Office of Water

1 September 2010

Proposed Development Activity - 89 George Street, Parramatta, Application NCA/3/2010

DUXTON DEVELOPMENTS 89 GEORGE STREET FLOOR PLAN - GROUND FLOOR

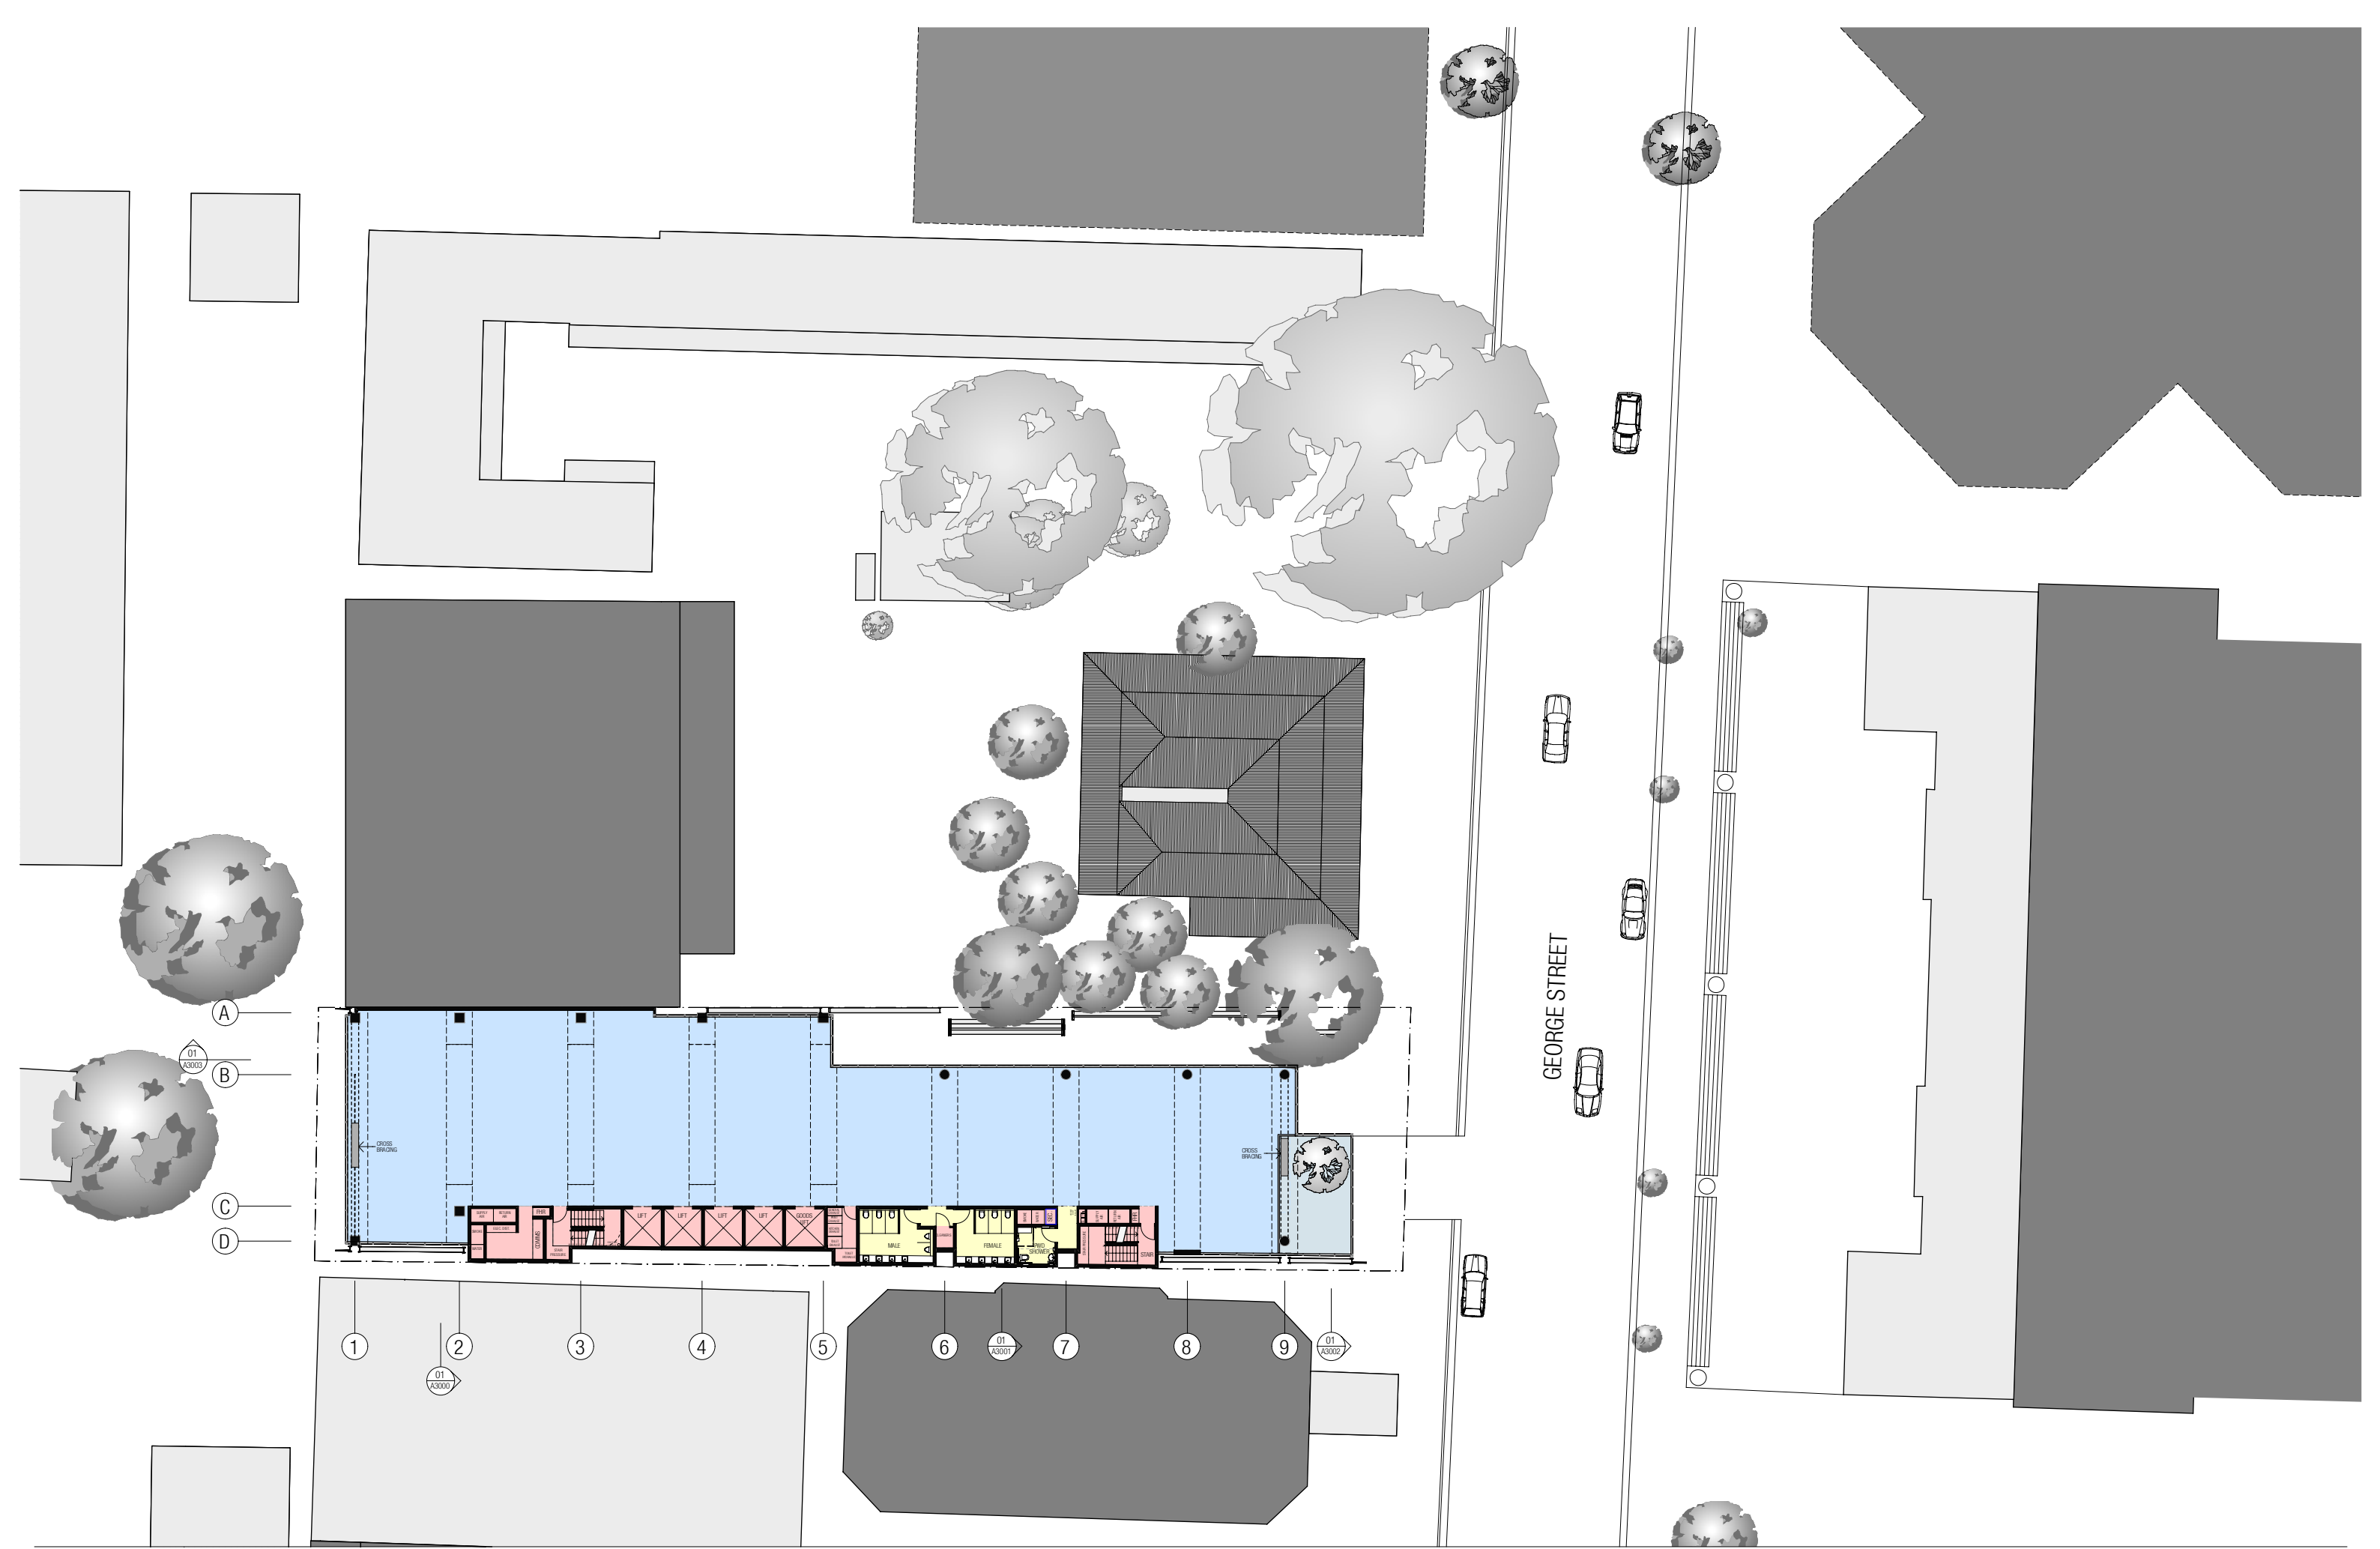
- The site sketch by Douglas Partners indicates the presence of shallow groundwater.
- The design sketch of below-ground voids by Enstruct includes provision for tanked basement construction.
- The contamination and acid sulphate soils assessments reported by SMEC Testing Services indicate the potential for adverse impacts from the development.

Given these considerations, it is recommended that the basement areas be built as 'tanked' (i.e. waterproof) constructions to prevent future adverse impacts on occupants and the surrounding environment as a result of (potentially aggressive or contaminated) groundwater reporting to the below-ground voids. Council may also wish to apply a requirement for the
